From: Thomas Callaway
Sent: 15 November 2013 15:09
To: 'Karl Gebhart'; Peter Cleveland
Cc: Webster, Gary [REDACTED]
Subject: RE: Brooks Nursery - Revised layout and outfall details comments

From: Thomas Callaway
Sent: 14 November 2013 15:24
To: Peter Cleveland
Subject: Brooks Nursery - Revised layout and outfall details comments

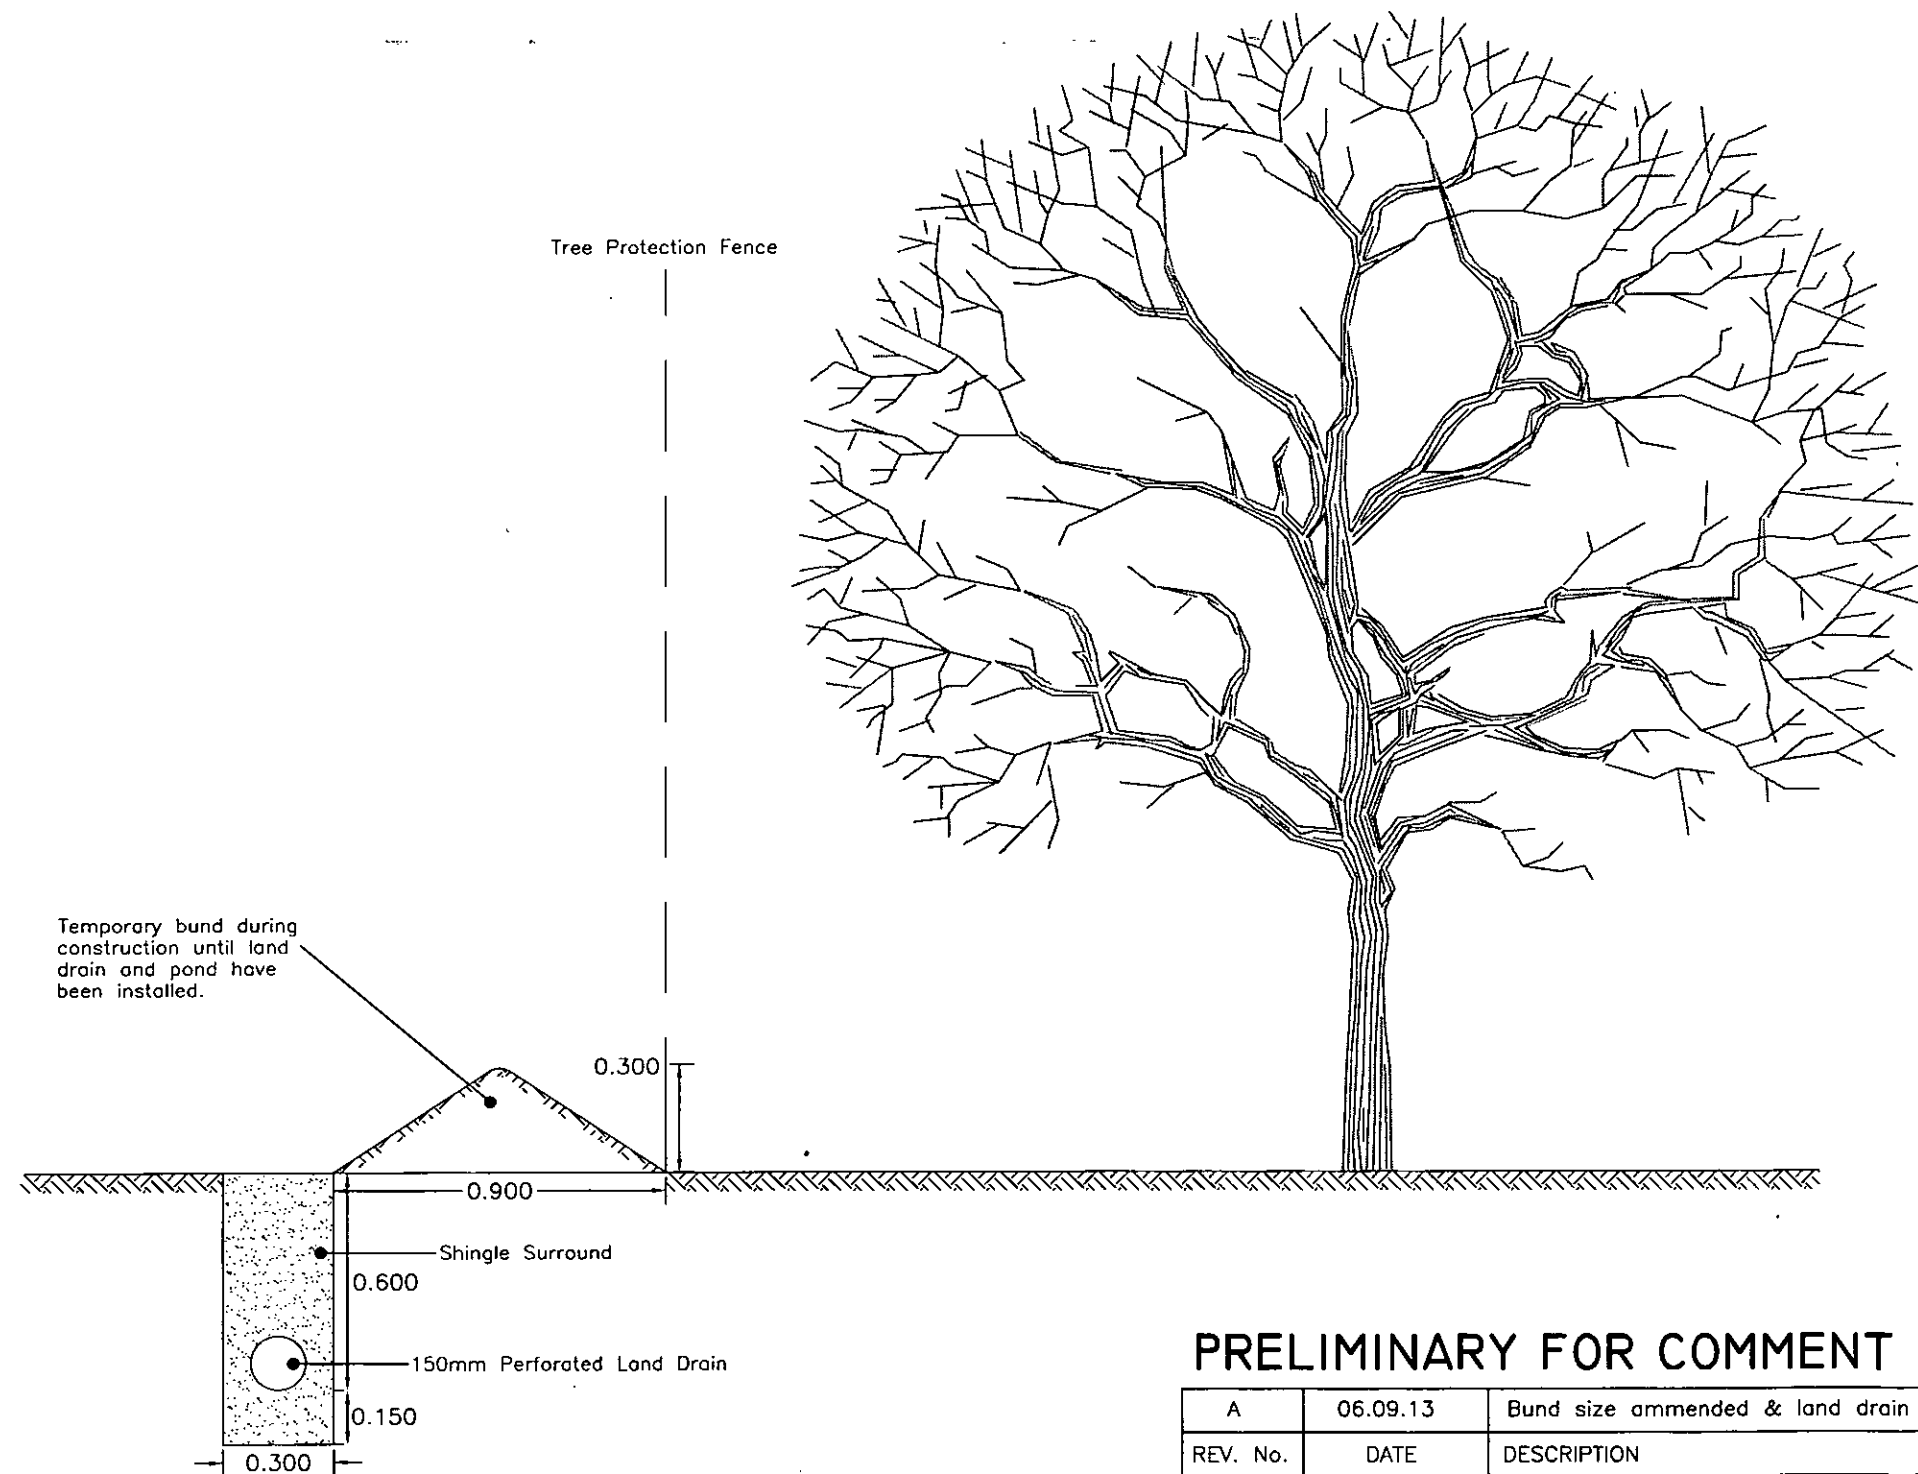
1. Grille not required for headwalls
2. 150mm drop required below pipe on headwall
3. Query re-aligned watercourse, does this mean de-silted watercourse?
4. Level of de-silted watercourse bed required
5. Discrepancies between pond levels on drawings and Micro Drainage calculations (pond should still function okay)
6. Invert levels should step down through the Hydro-Brake chamber (jumps from 8.35 to 8.40)
7. Query 65.610 level at base of chamber?
8. Provide Hydro-Brake specification
9. Manhole required for land drain in plot 9
10. Land drain headwall required, considering previous points for pond headwalls

Further to your email yesterday I can confirm we have addressed the 10 points raised adding where necessary additional information & specifications.

I therefore attach revised copies of the drainage layout and Pond Outfall details for your approval.
